**Consultation Response from KC,  
Highways Development Management**

**2025/90734 Whinney Dene, West Field Lane, Wooldale, Holmfirth, HD9 1RD**

**Demolition of existing stables building and erection of detached dwelling**

**Date Responded: 30/04/2025**

Date 04/03/2025		A1	
Drawing		2555	Scale
Proposed site plan		R A	1:500
		4

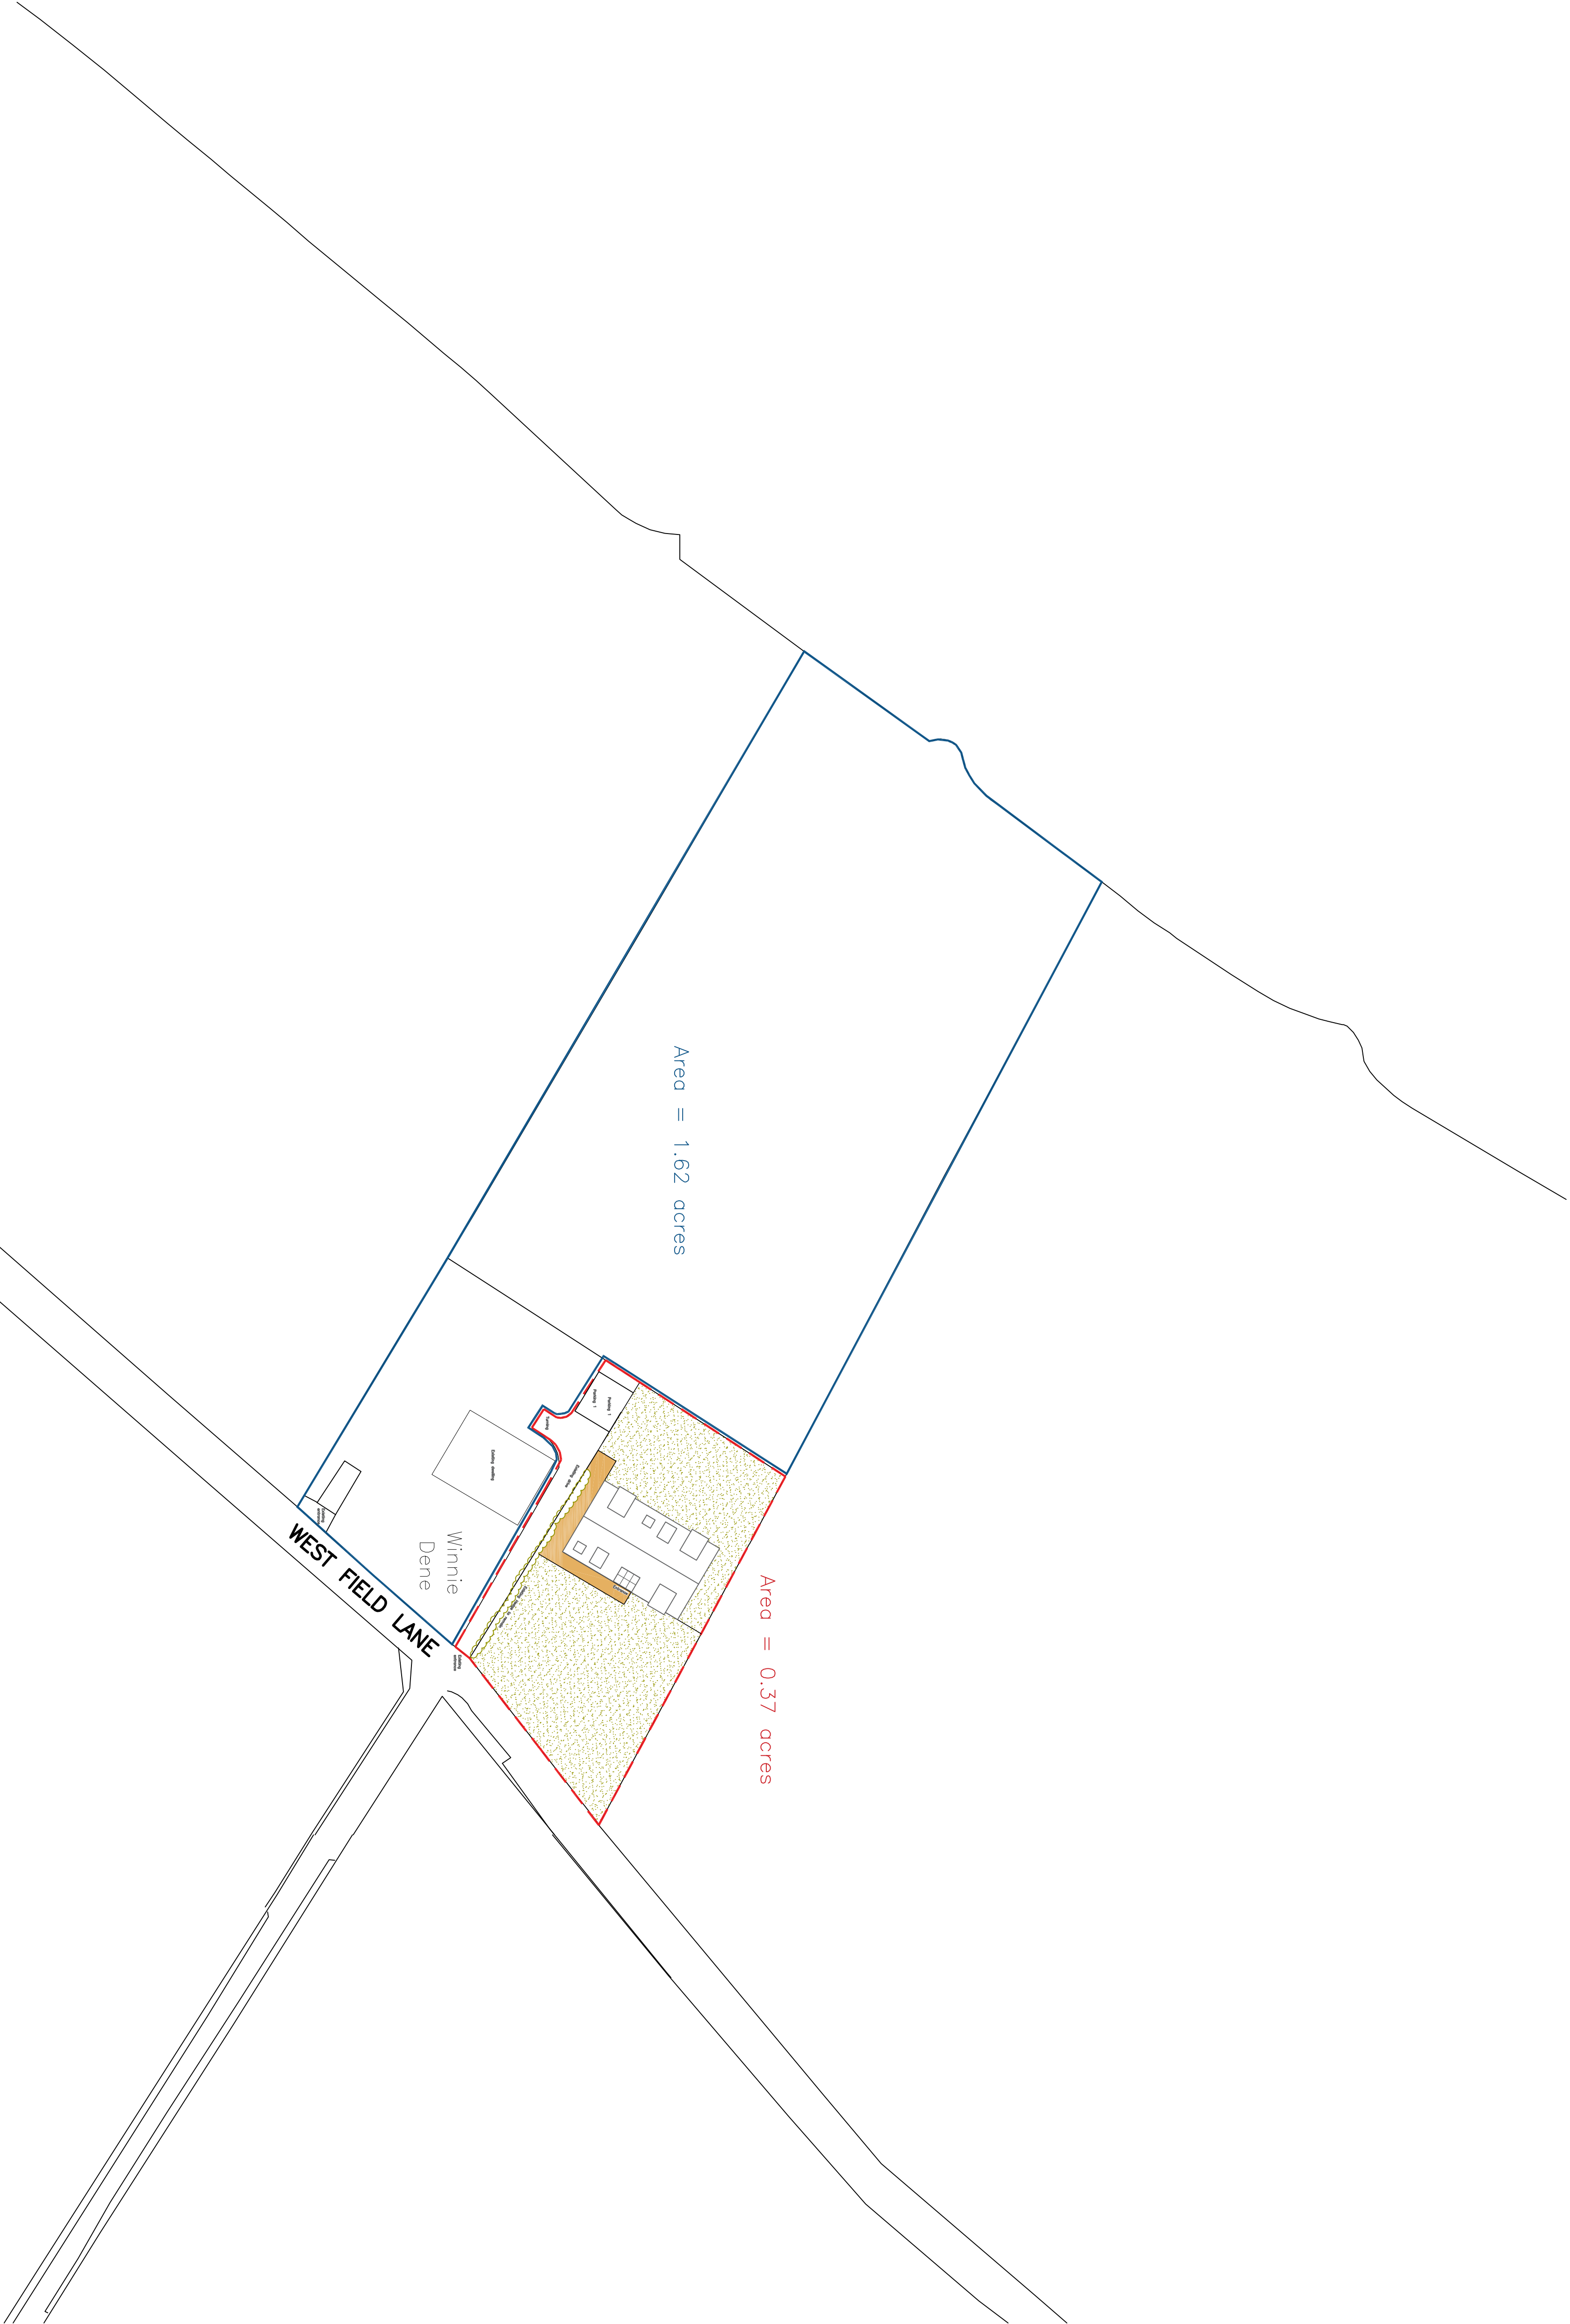
Vehicle access to the site from West Field Lane will remain as existing and is unaffected by the proposals.

Parking is proposed for 2 vehicles together with internal turning which is acceptable

The approved vehicle parking areas will need to be surfaced and drained in accordance with the Communities and Local Government; and Environment Agencies 'Guidance on the permeable surfacing of front gardens (parking areas)' published 13th May 2009 (ISBN 9781409804864) as amended or superseded.
